CITY OF ALBUQUERQUE

September 2, 2016

RE: **Silver Ave Townhomes**
Grading and Drainage Plan
Engineer's Stamp Date 8-18-16 (File: K16D072A)

Based upon the information provided in your submittal received 8-30-2016, the above-referenced plan is approved for Building Permit.

SHEET TITLE
MASTER GRADING & UTILITY PLAN

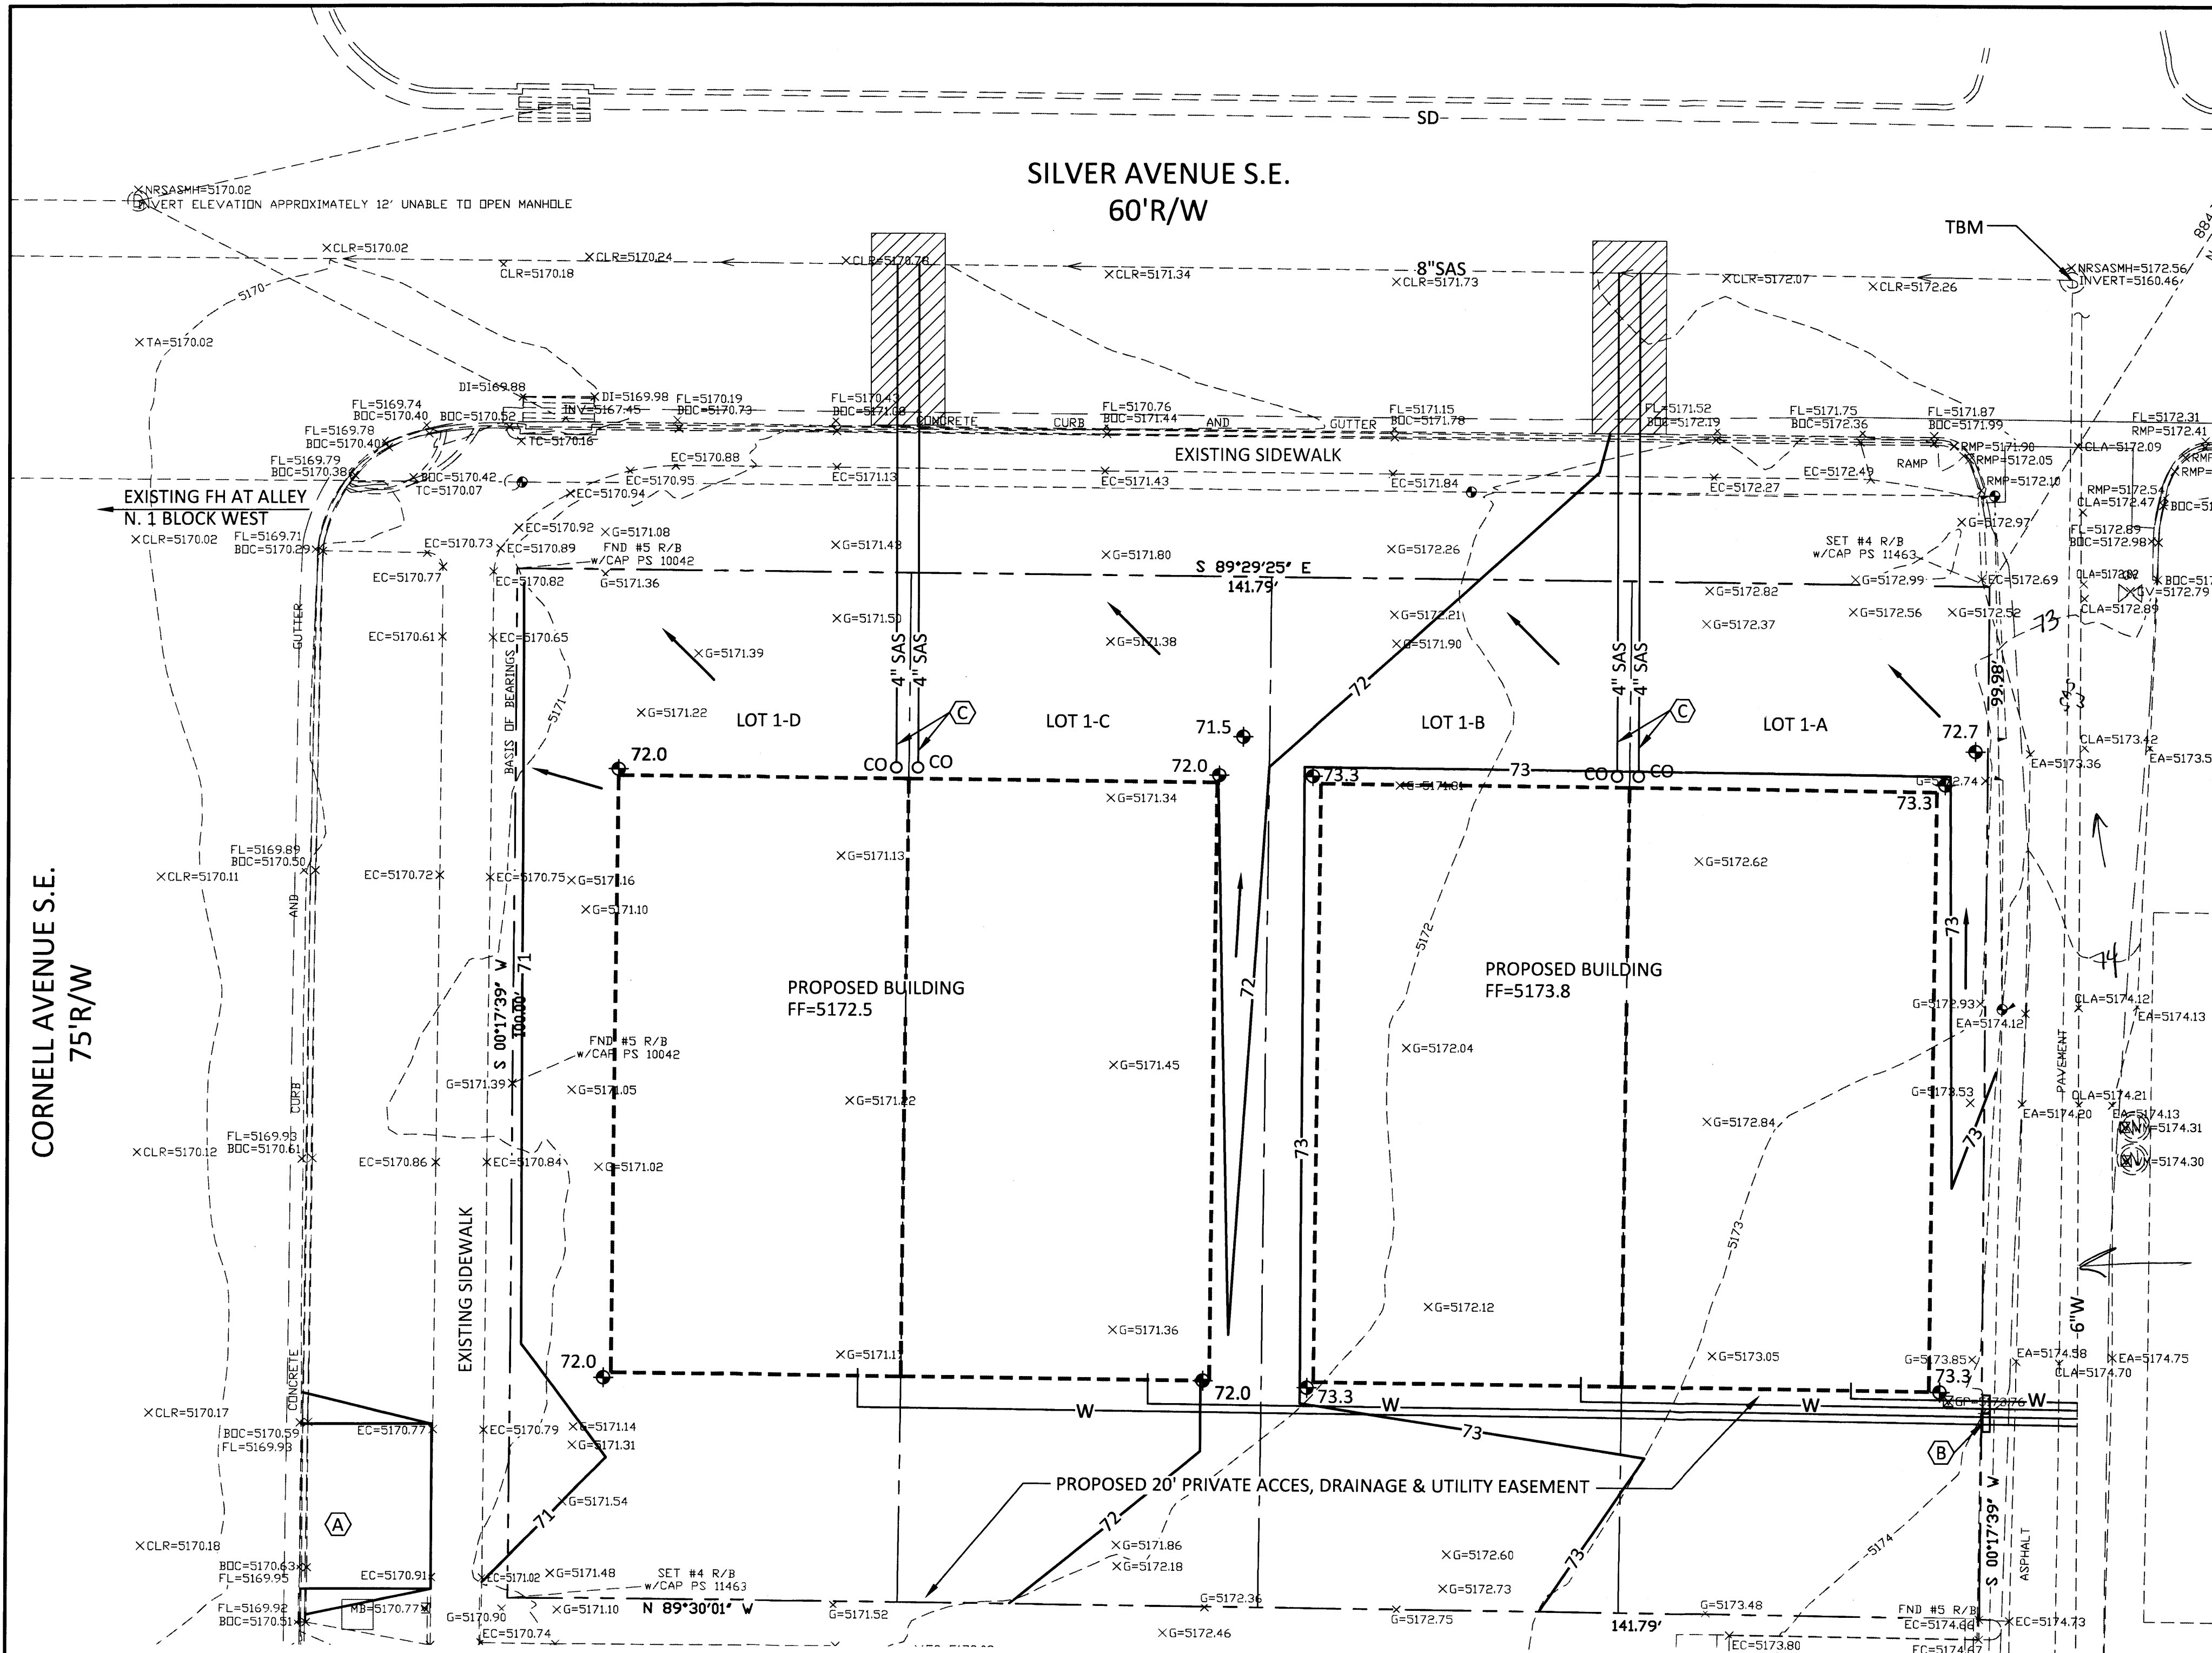
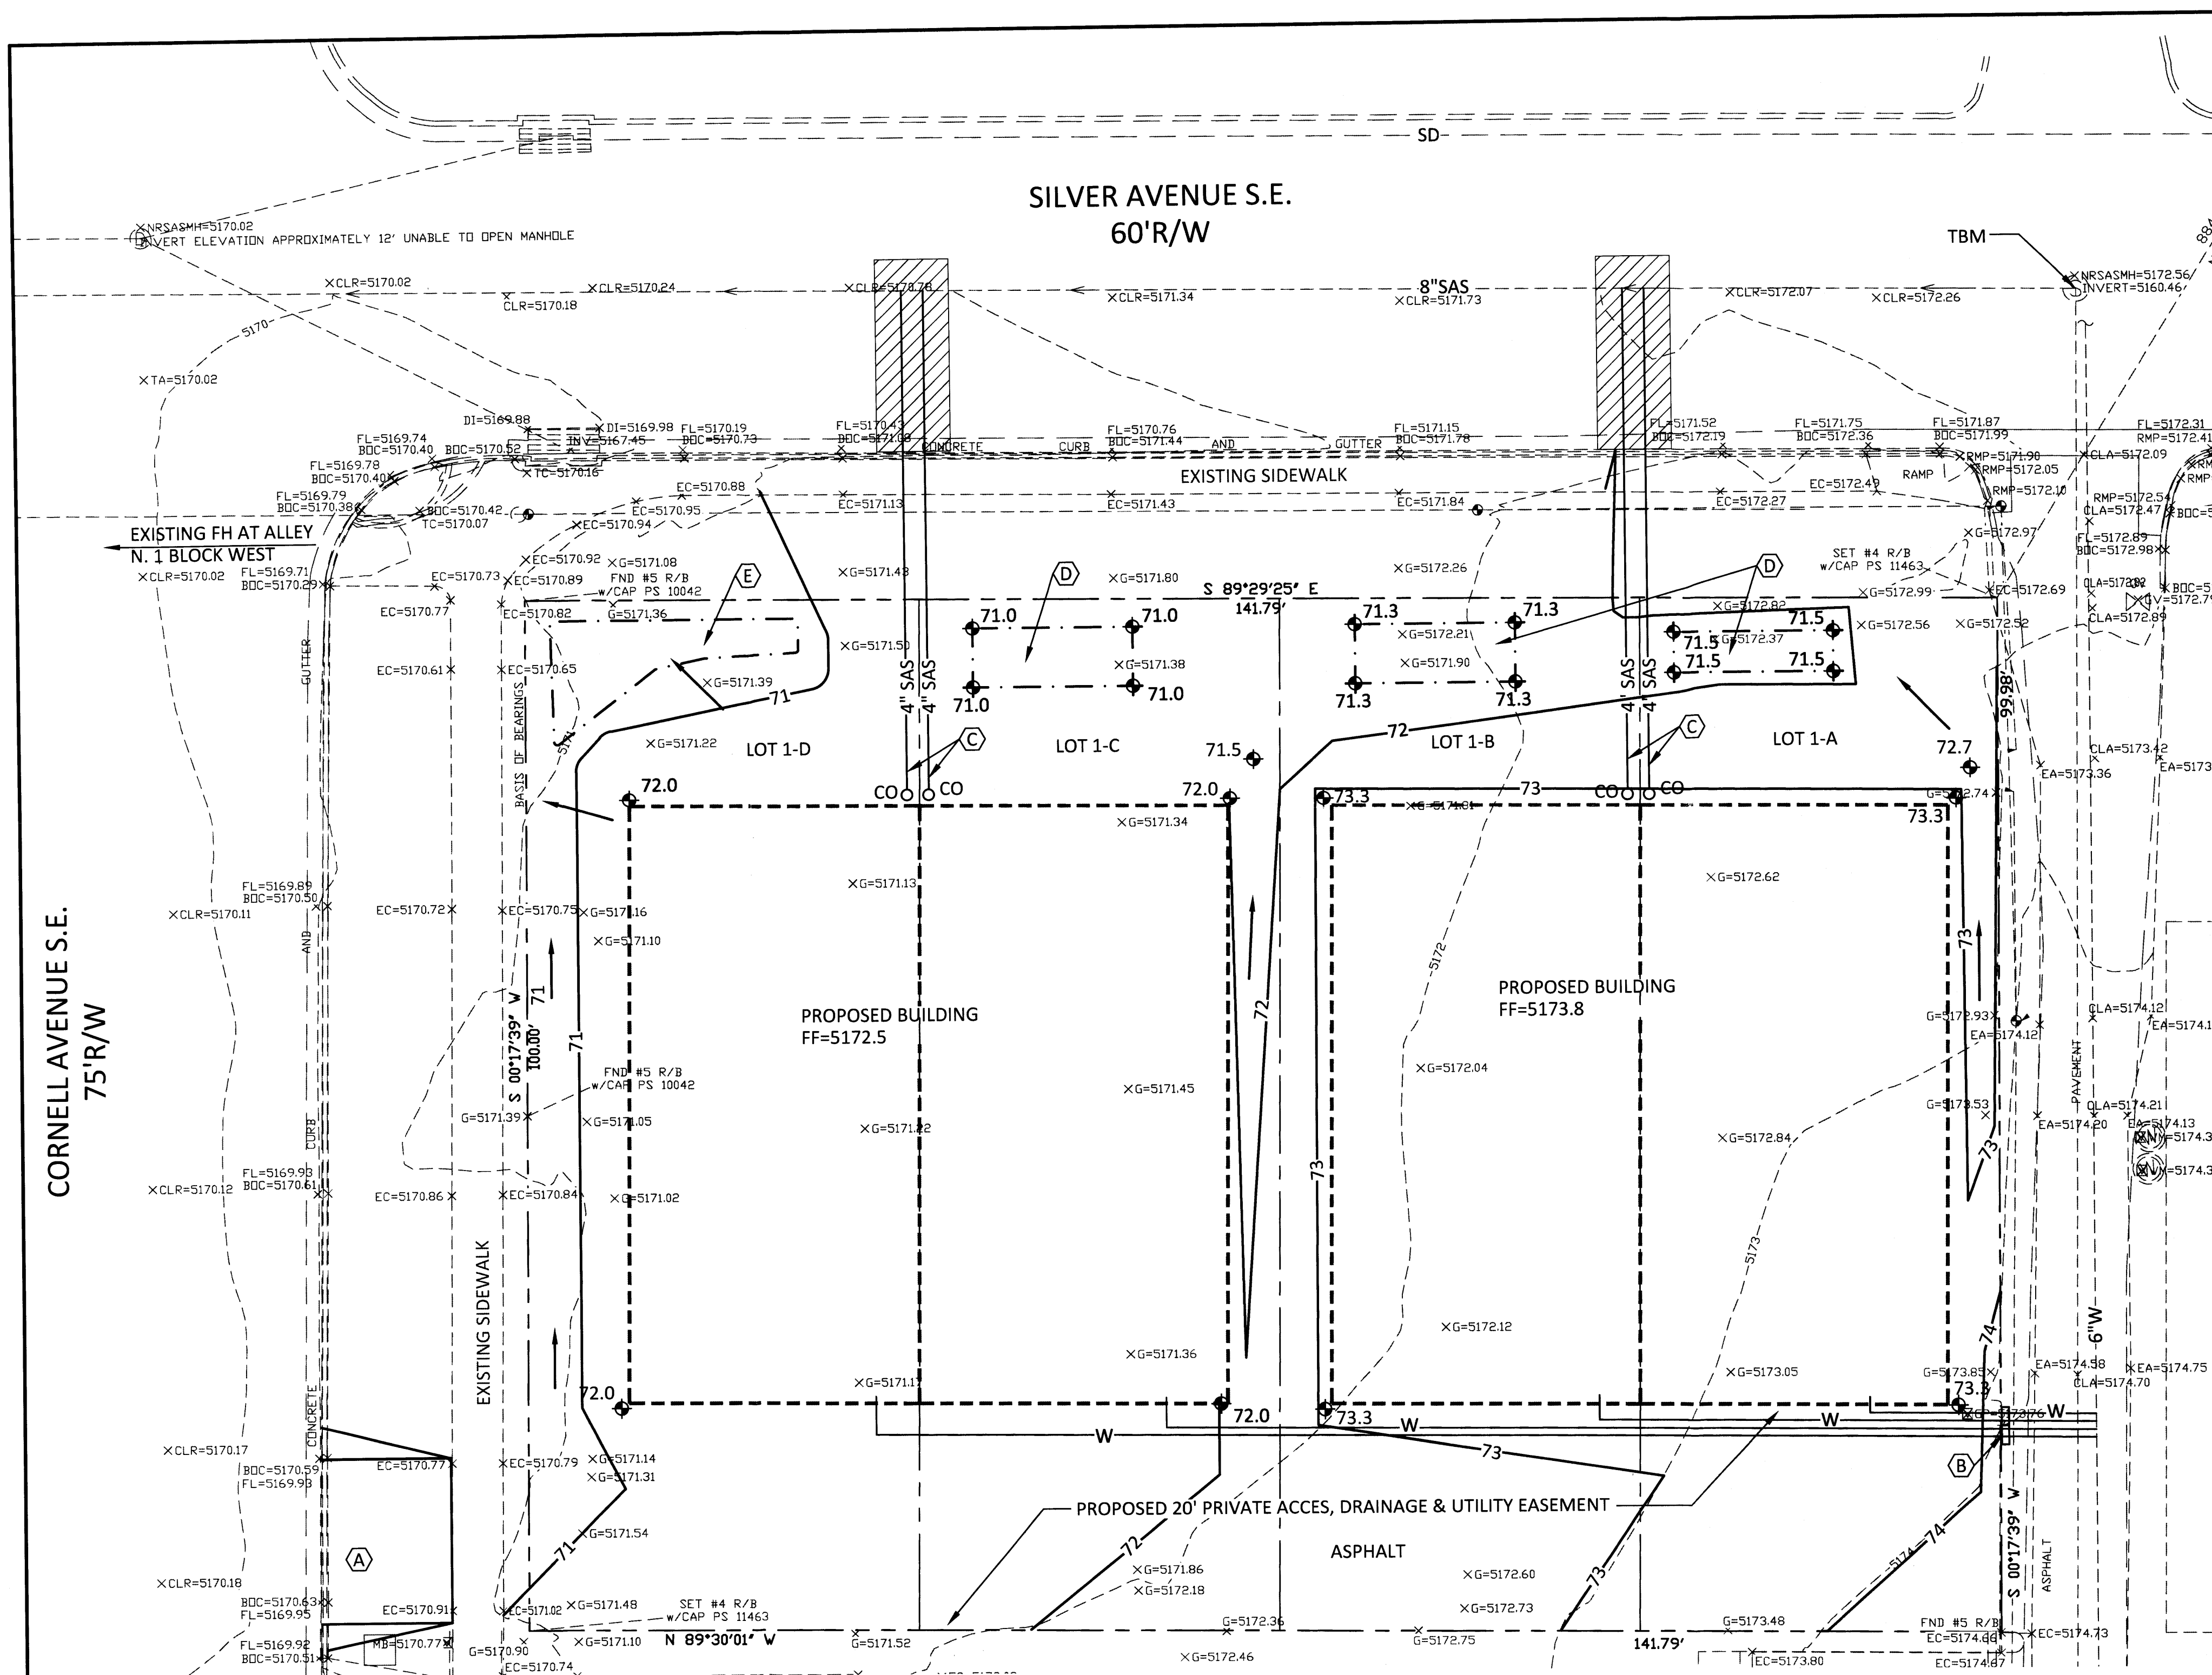
1. Retain the first flush. Per the City Drainage ordinance, the 90th Percentile Storm Event, which is 44 inches, is to be managed. Reduce 0.44 inch by the 0.1 inch for the initial impervious abstraction in Table A-6 of Section 22 of the DPM. Multiply the remaining 0.34 inch by your impervious area. This is the portion to retain. The front yards are a good location to retain the first flush on this site.
2. Discuss the existing offsite flows from the east that are crossing the alley and entering the property.
3. Confirm the proposed 73 contour on the east side of the property is tying into an existing 73 contour. It appears the existing contour is 74.

1. The first flush volume has been retained with added shallow depressions in the front yard areas. Drainage calculations have also been added within the drainage narrative.
2. Offsite flow of 0.1 CFS has been calculated and discussed in the drainage narrative.
3. The proposed 73 contour has been revised along the east side of the site. The proposed 74 contour has also been added at the SE corner of the site.
